PLANNING AMENDMENT

Application No. **A06/1124/96/1**
 Date Registered **20 AUG 1998**
 Case Officer **J. Blacklock**

Description: Residential development
(five bungalows)

Location: Topsgate
Gedney

**AMENDED PLAN**  
 Ref. A1

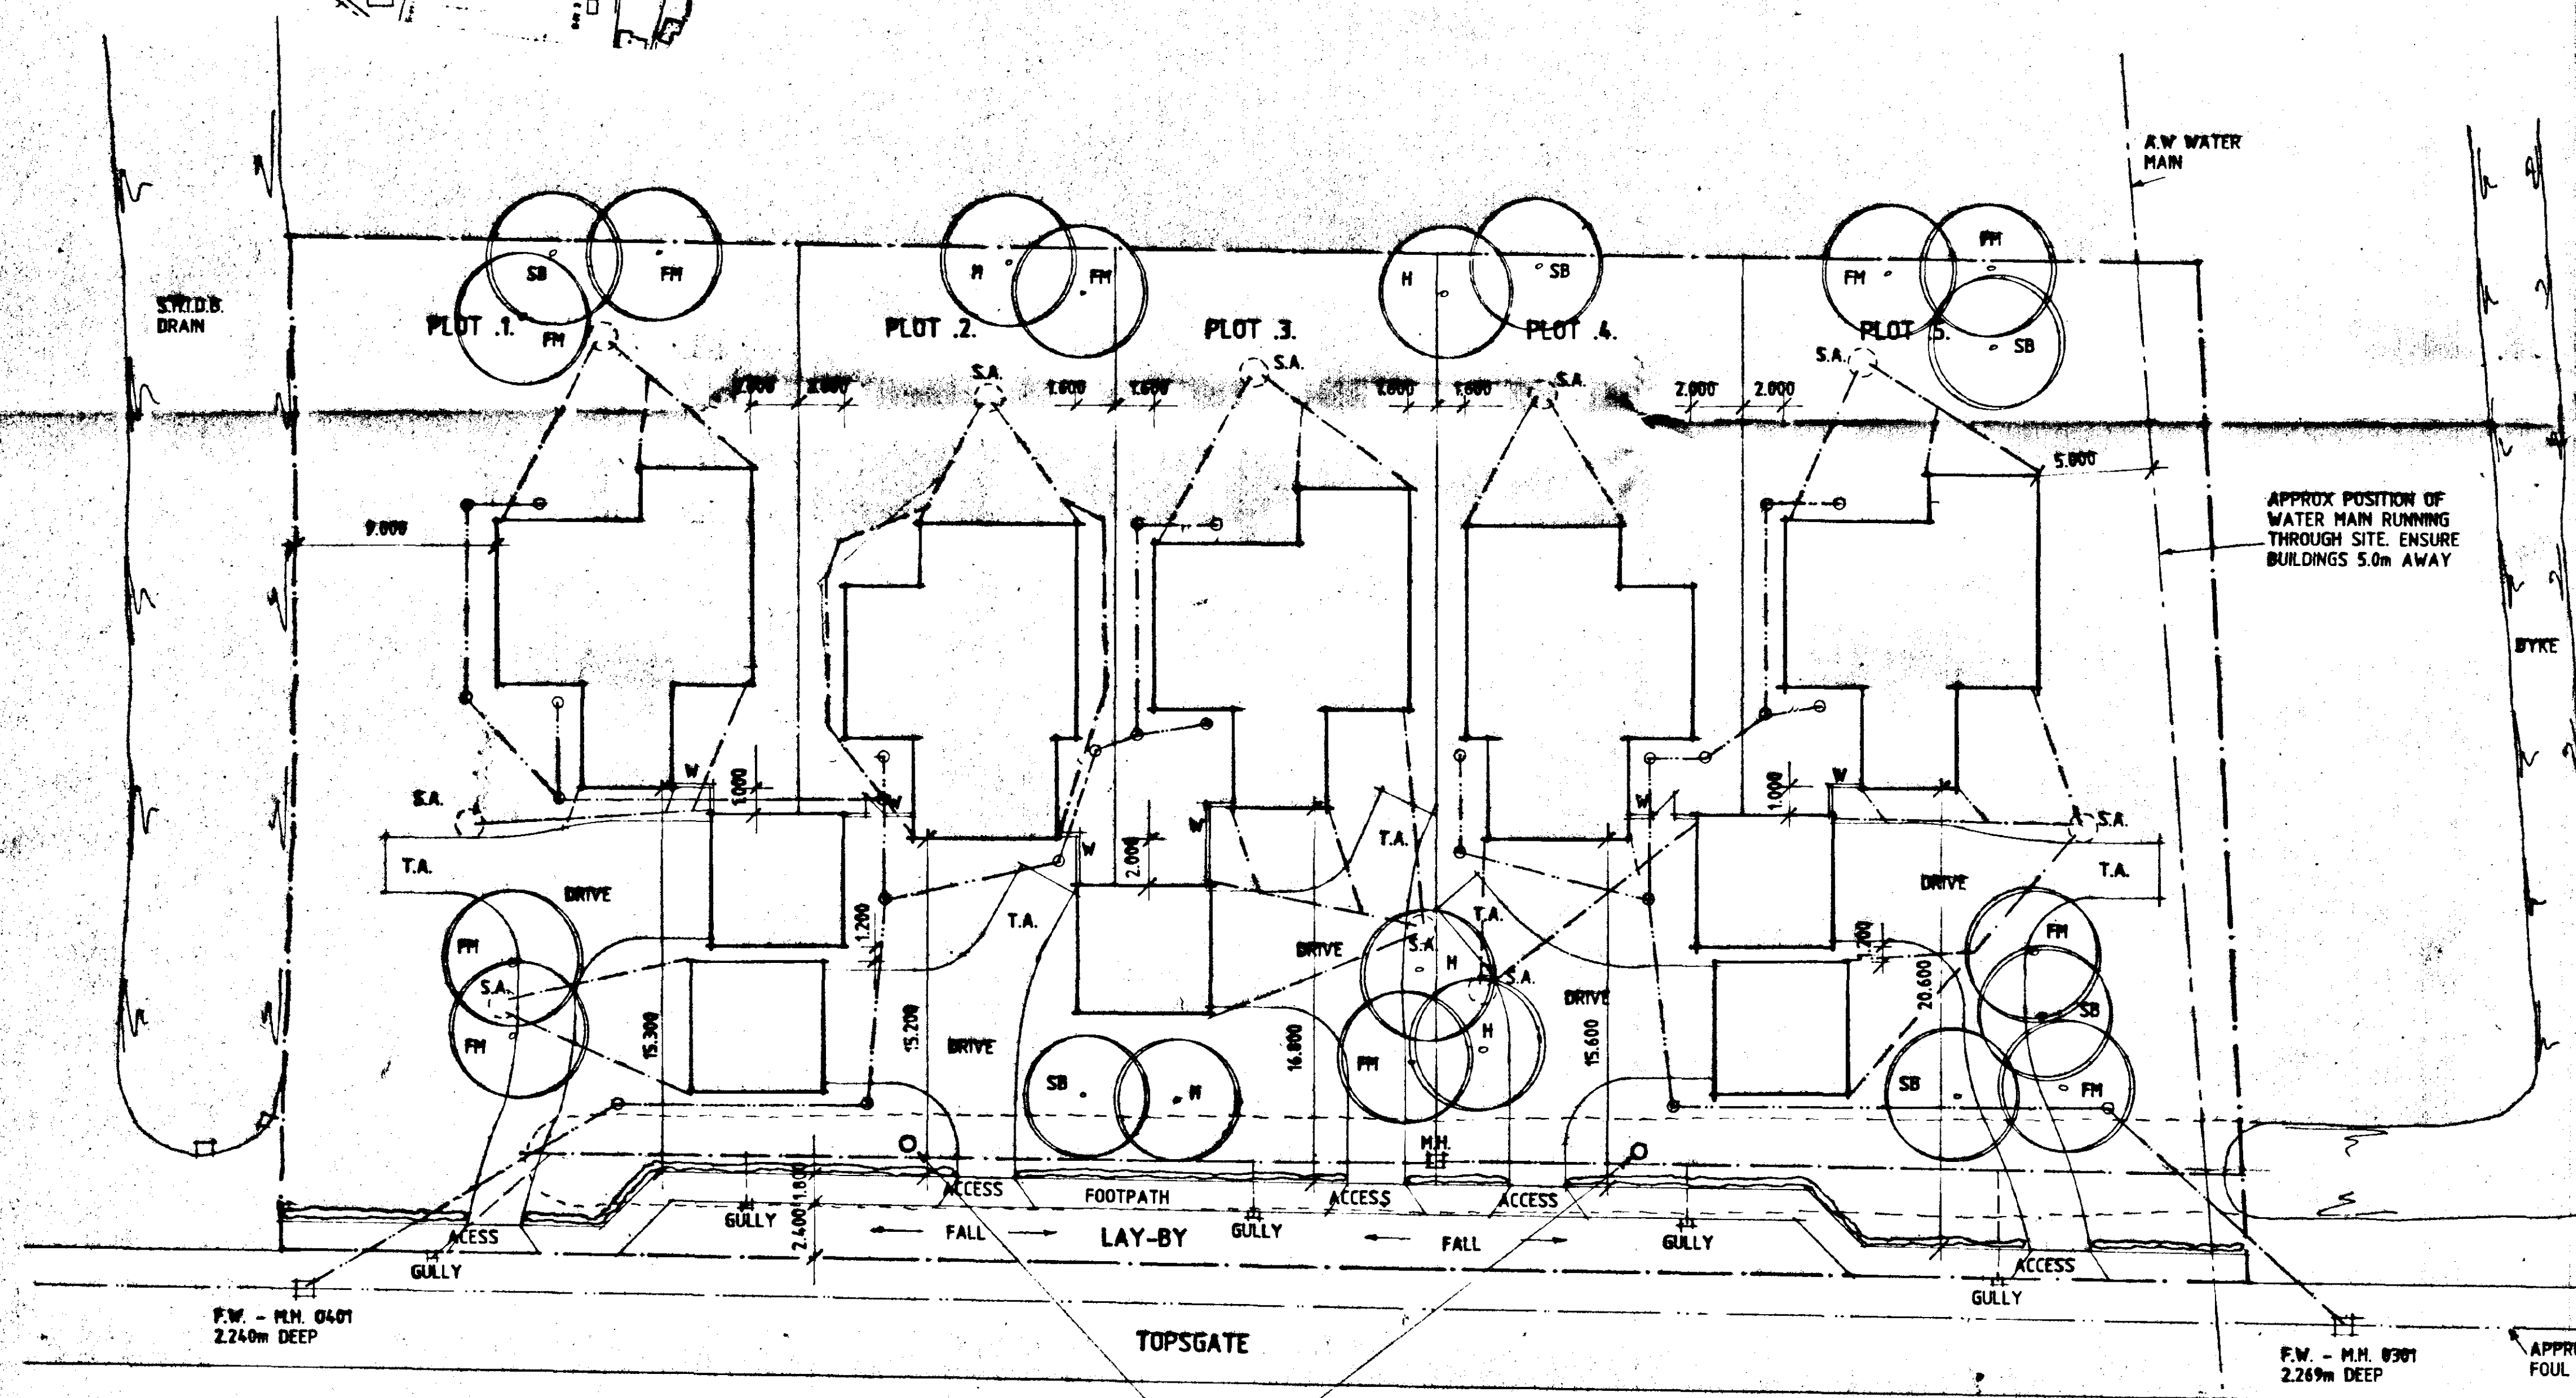
**DWELLING ON PLOT 1 TO BE
 HANDED**

Amendment: Dwelling on plot 1 to be handed.
(Drg No. 771886/1).

The amended details submitted in respect of the above proposal have now been considered, and I am able to inform you that there are no objections to the amendment being implemented to the extent described above.
